PROSPER COLLECTION

ACCESS DESIGN REVIEW – STATE SIGNIFICANT DEVELOPMENT APPLICATION (SSDA)

5-9 Cowan Road, St Ives, NSW, 2075

Project number: 251480
Revision: ADR 1.2
Date: 17 September 2025

DRAWING BY: CAD Technician XX	CHECKED BY: Checked by XX	
SCALE: 1:100 @ A0	DRAWING NO: DA100	ISSUE: P5
PROJECT NO: 2518

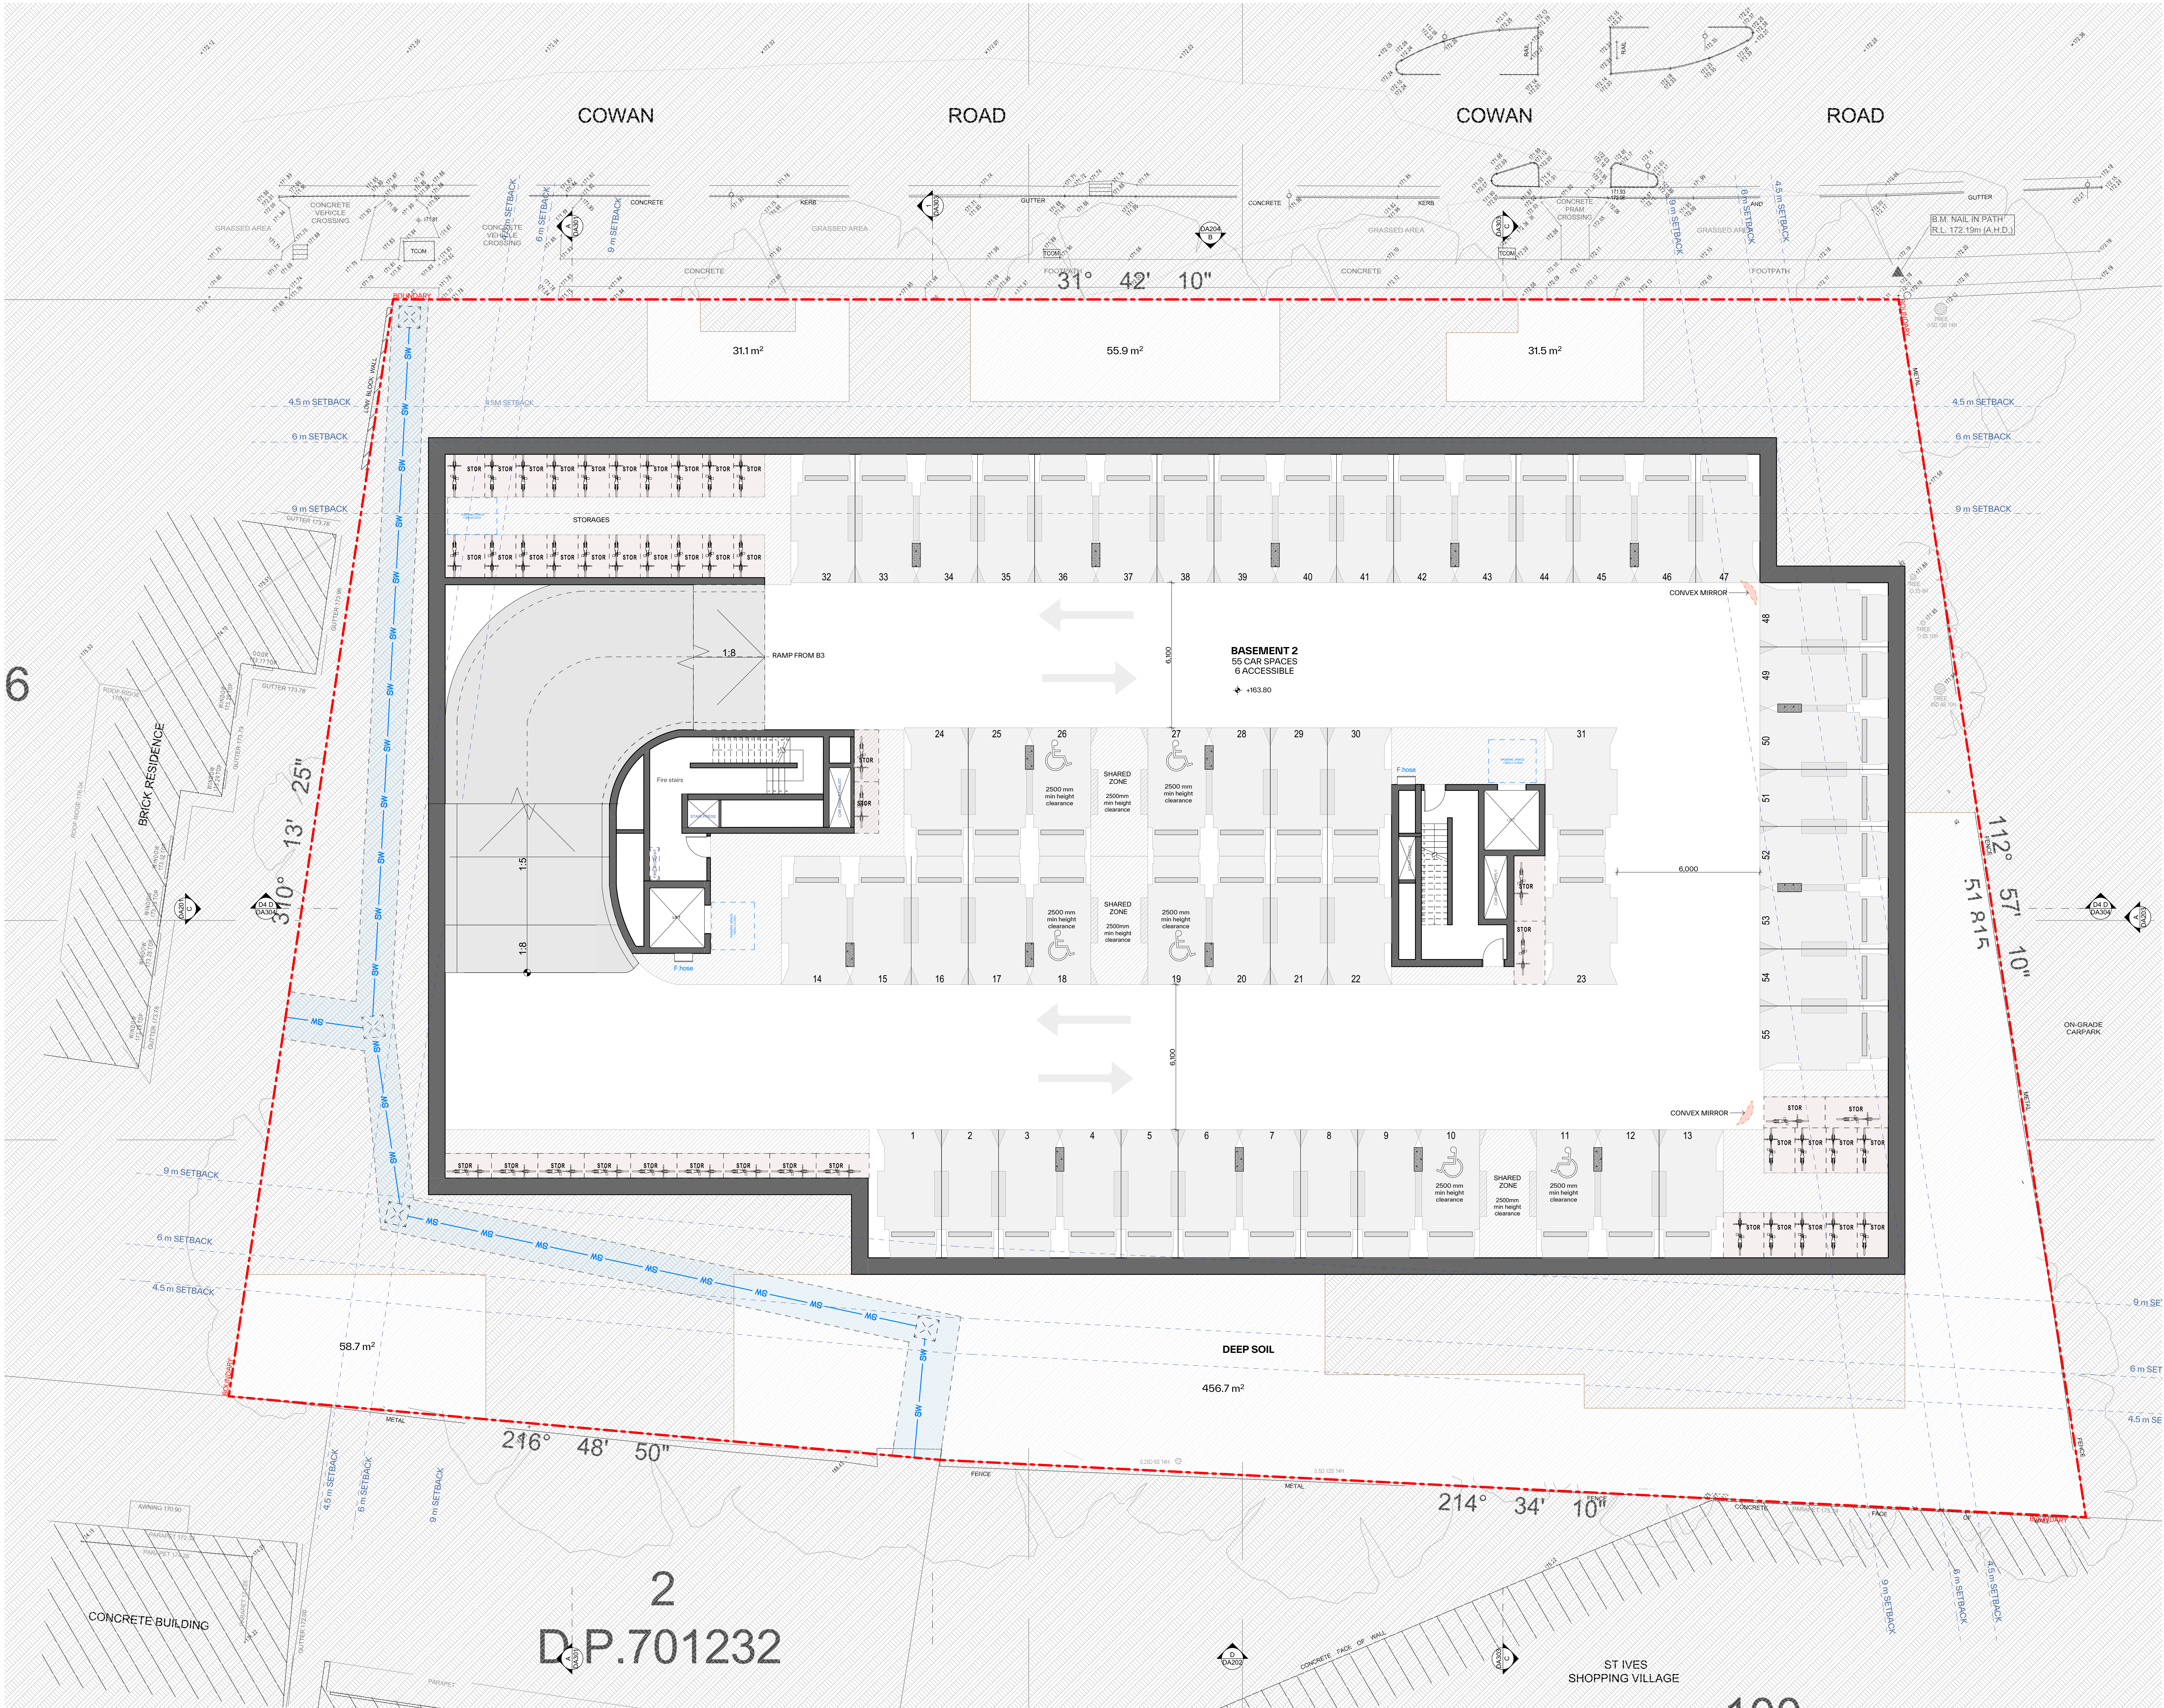
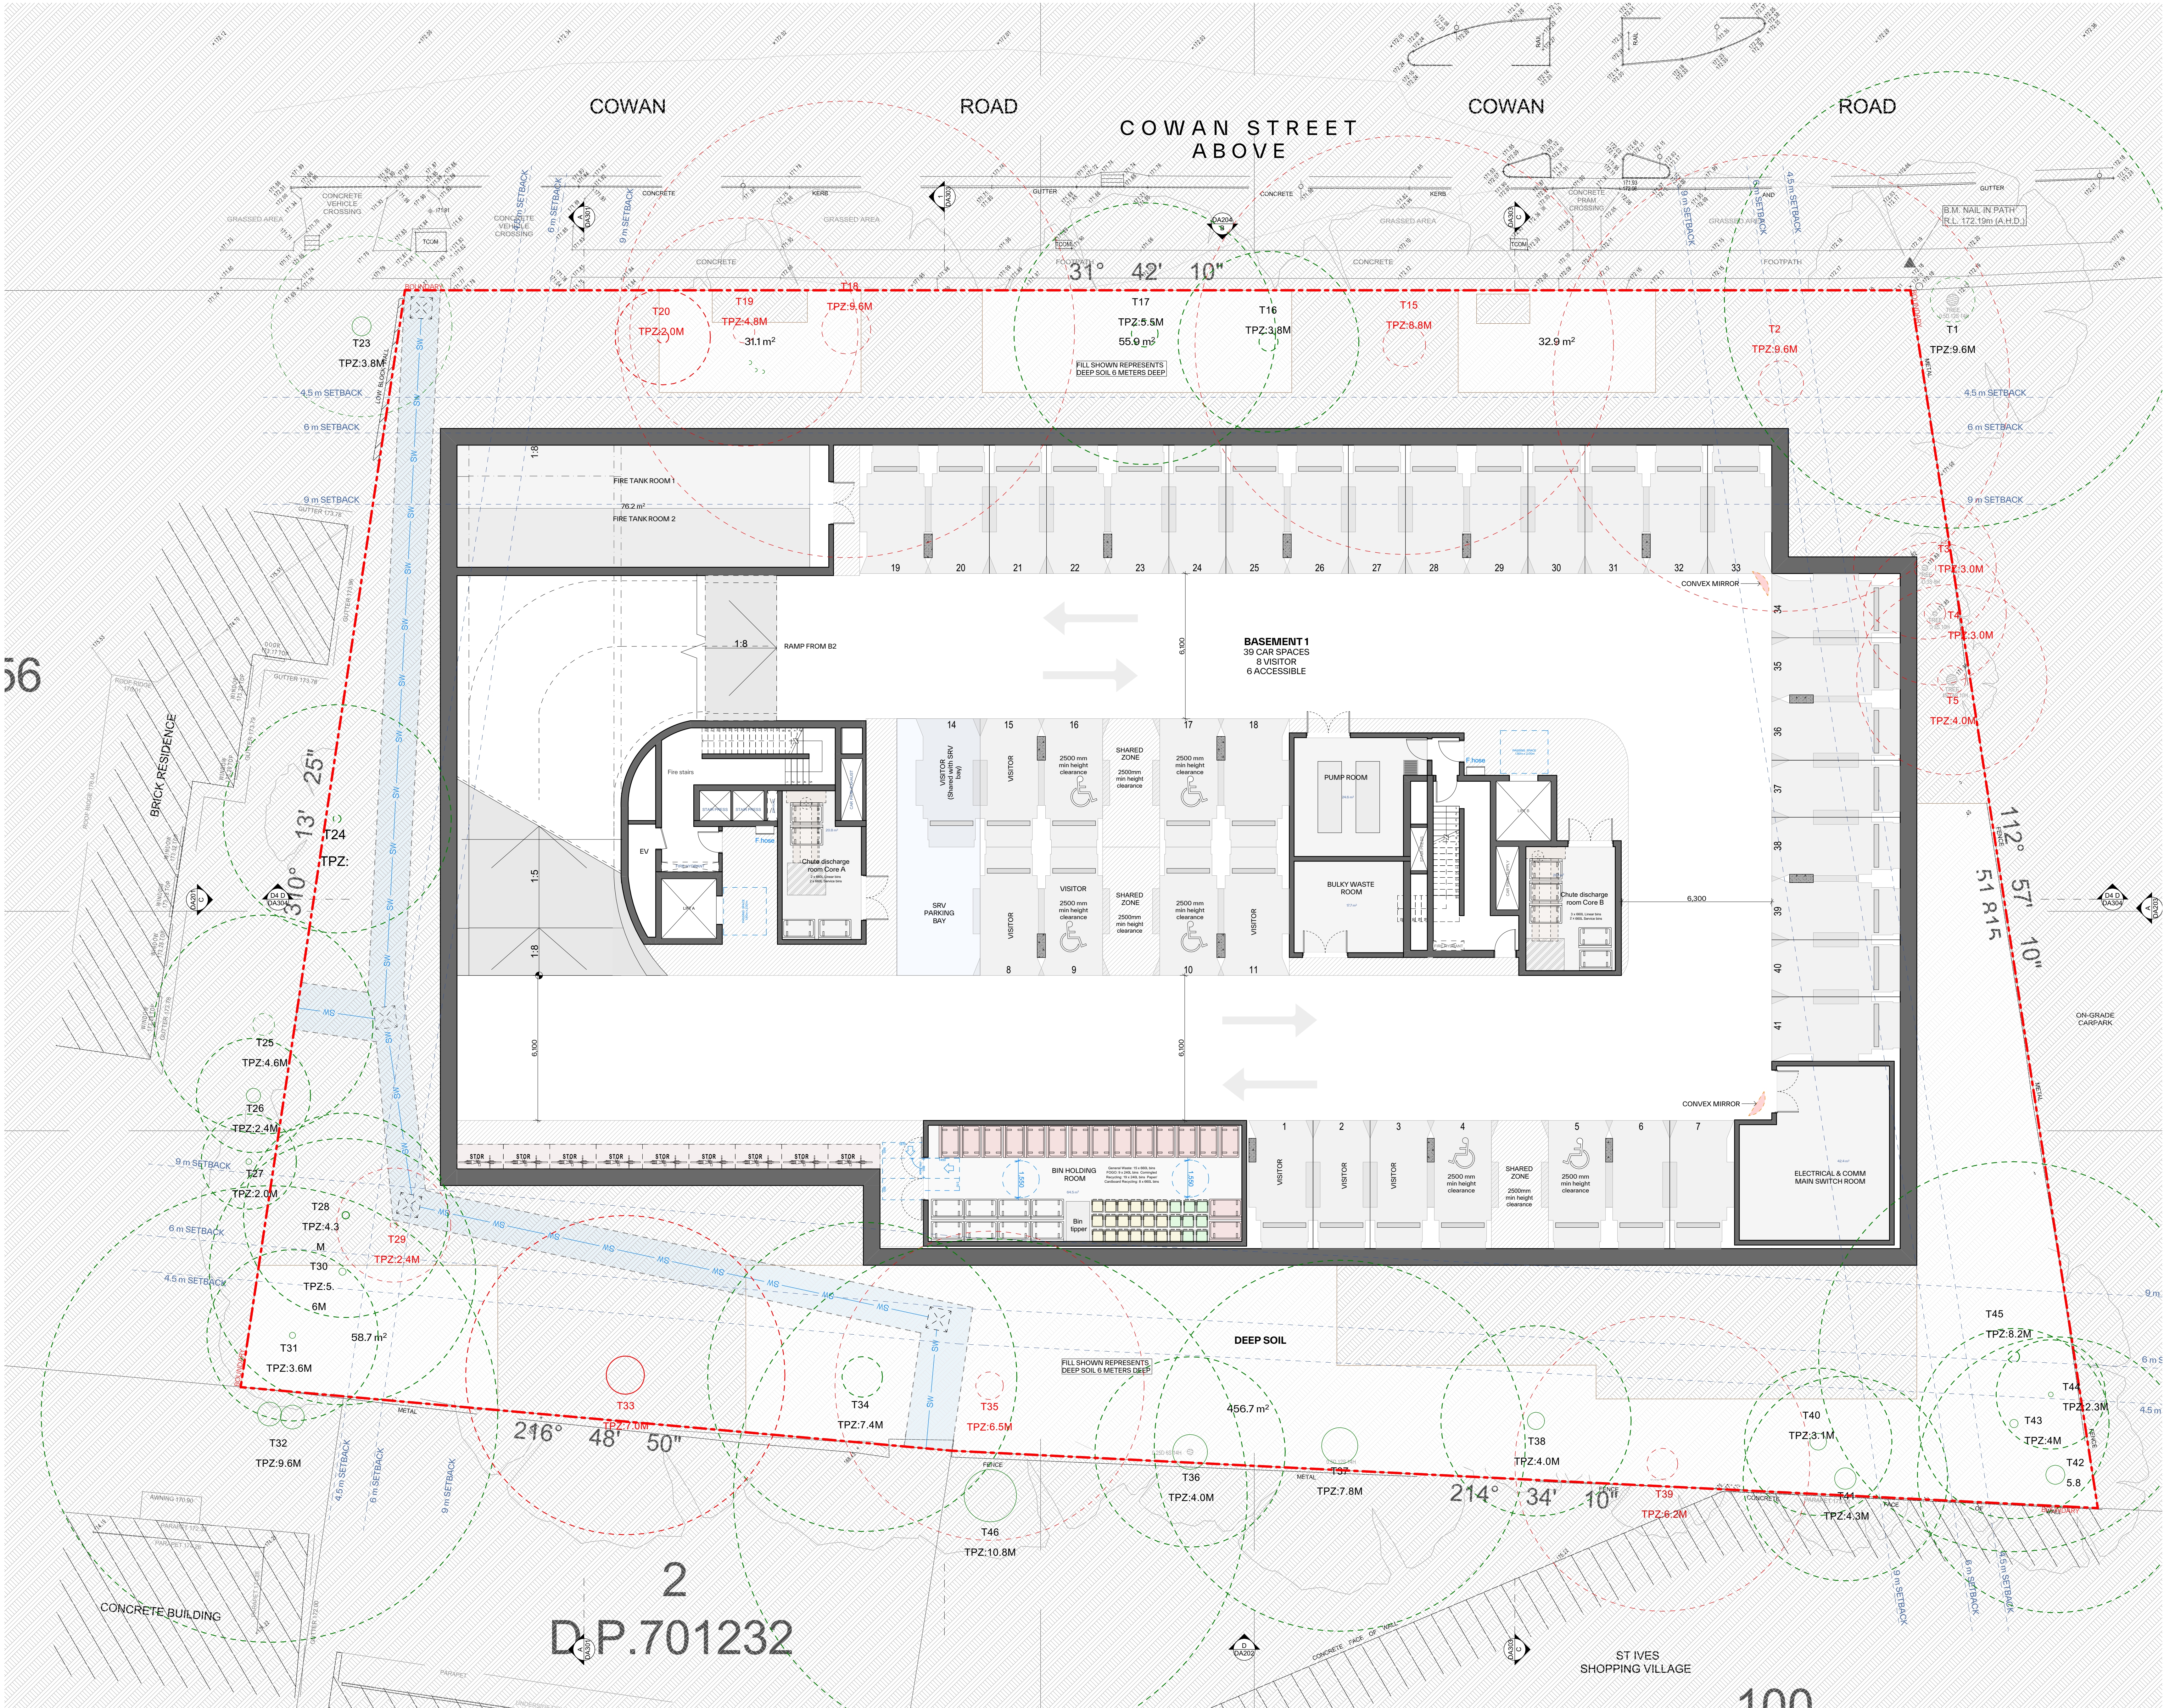
Whilst buildings of this classification (Class 2) are not required under the minimum prescriptive measures of the BCA to incorporate accessible car parking, AS4299 requires a car space for each unit nominated to comply. An accessway is available through a common open space from these parking bays to the passenger lifts within all basement levels.

The car parking as currently detailed requires amendment to be capable of meeting the provisions of access as prescribed by the Australian Standards 4299. The documentation will be further reviewed as the design progresses to ensure compliance is met.
